12 Lambert Street Review Comment Response

Thank you for your review comments dated June 10, 2016 regarding project ID: 2016-01159 for the DiPietro Single Family at 12 Lambert Street. I have added my responses to your comments in **bold green** below.

GRADING/UTILITY PLAN
OF:
DIPIETRO PROPERTY
12 LAMBERT STREET
PORTLAND, MAINE
FOR:
DAVID DIPIETRO
221 VIRGINIA STREET
PORTLAND, MAINE

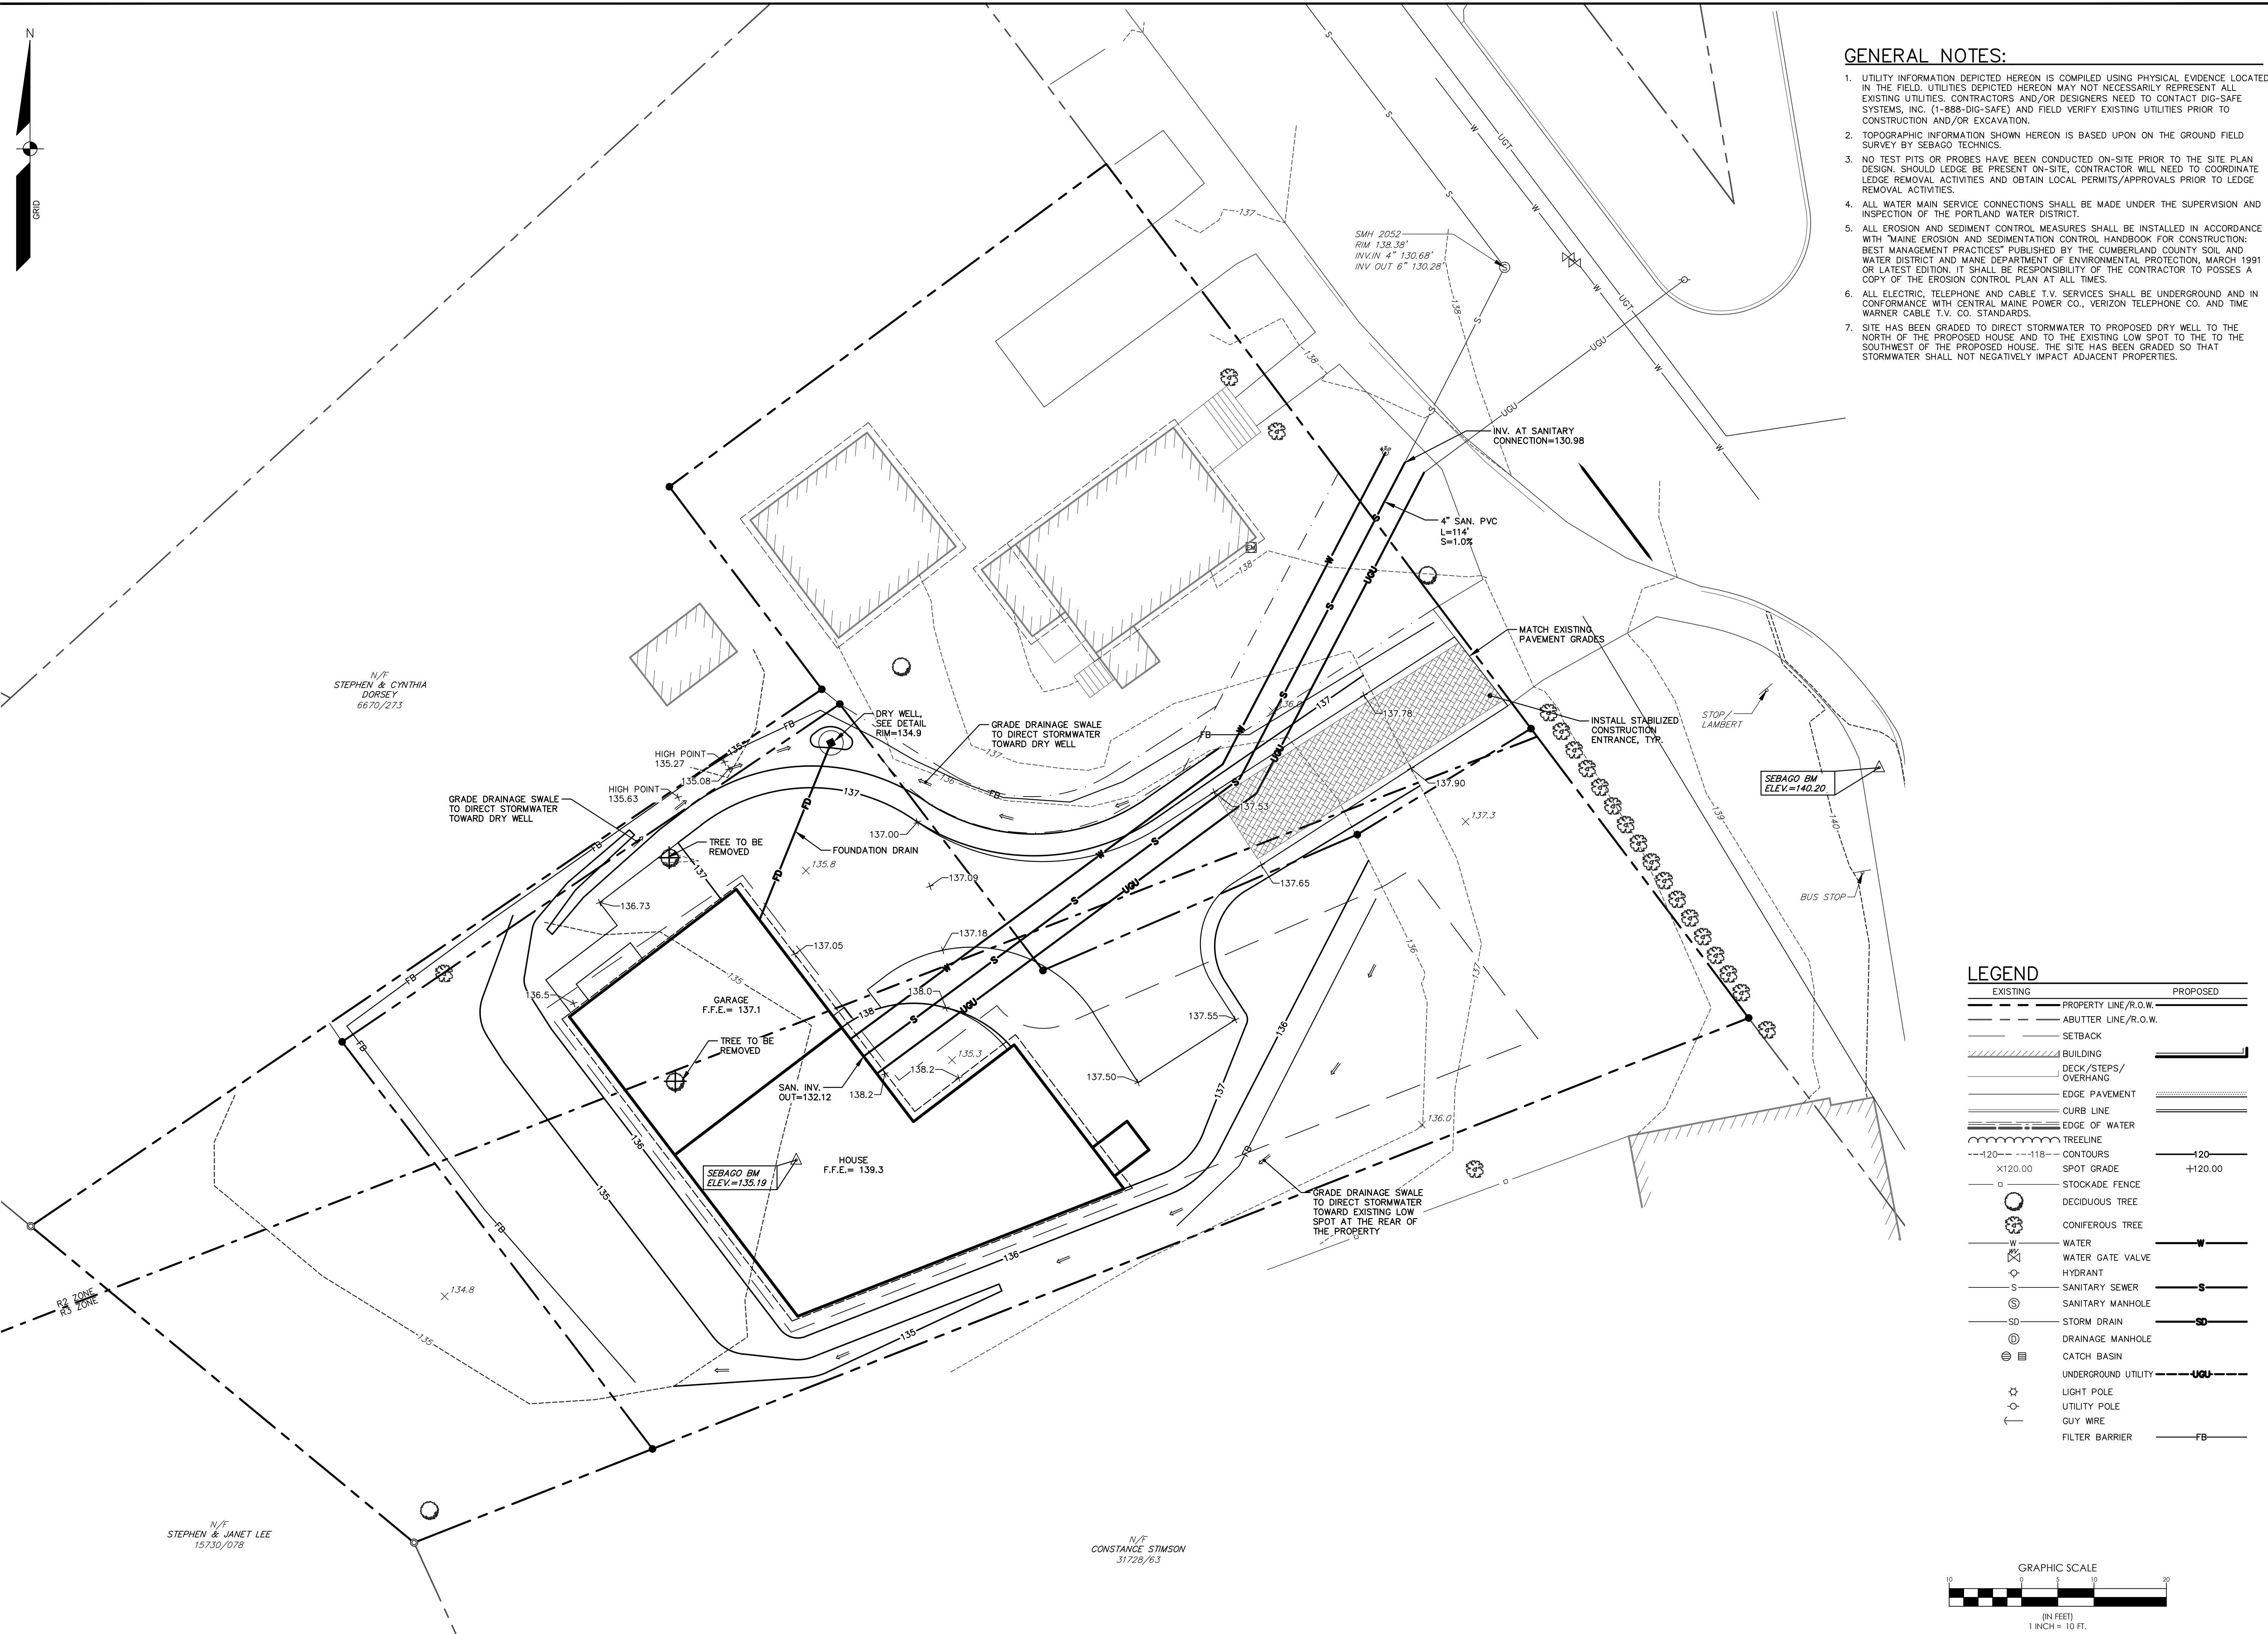
- *Please add the ground floor areas to the site plan. **Done***
- *Please add the soil type to the site plan. **Done***
- *Please revise the grading plan so that it is clear that neighboring properties are not negatively impacted by stormwater surface drainage, i.e., adding drip edge around the foundation, constructing an infiltration strip to capture driveway runoff, berming and*

swaling, etc. **We have altered the drainage design to emphasize protection to the neighboring properties by lowering the rim elevation of the drywell and adding spot grades along with additional contouring to depict a berm along the property line with a swale between the proposed home and the property line which will direct flow to the dry well. We have also added Note #7 to the Grading/Utility Plan (Sheet 2) which reinforces the intent of the drainage design.**
